Tel: 01903 737756
Email: planning@arun.gov.uk
www.arun.gov.uk/planning
Please ask for: Amy Anderson
Email: amy.anderson@terraquest.co.uk
Telephone: 0121 234 1390
Our Ref: LY/14/25/HH
Your Ref:
Date: 12th December 2025

Application for Planning Permission for Works or Extension to a Dwelling

Development: Single storey extension
Location: Ubuntu Priory Farm Station Road Arundel BN18 9PH

ROOF PLAN

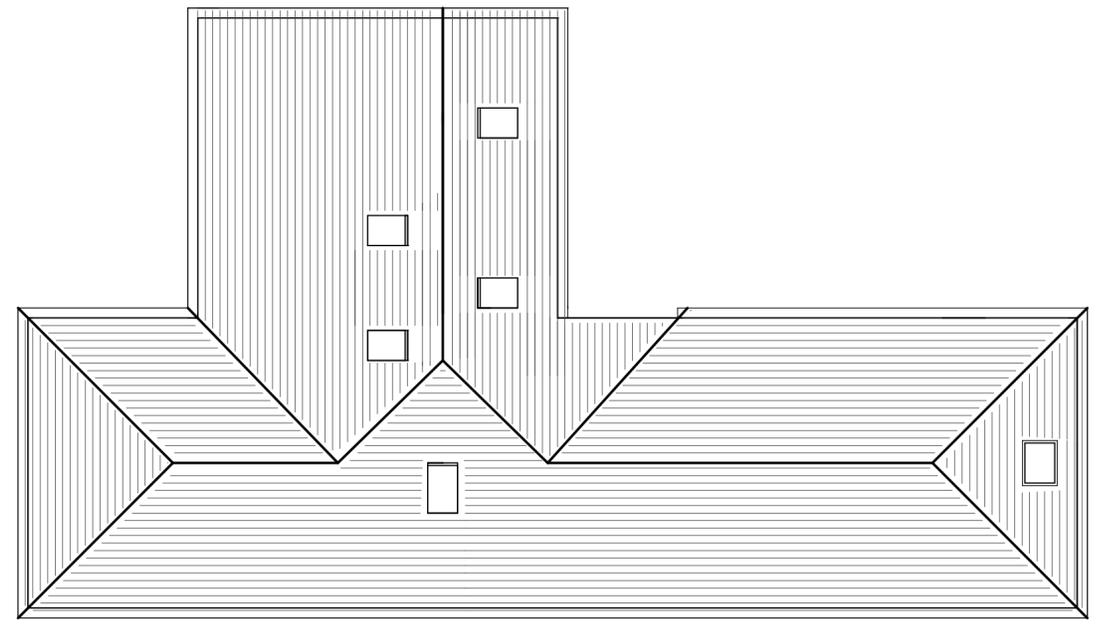
The existing and proposed NE Elevations are missing a roof light that is shown on the roof plans. Please review and amend.
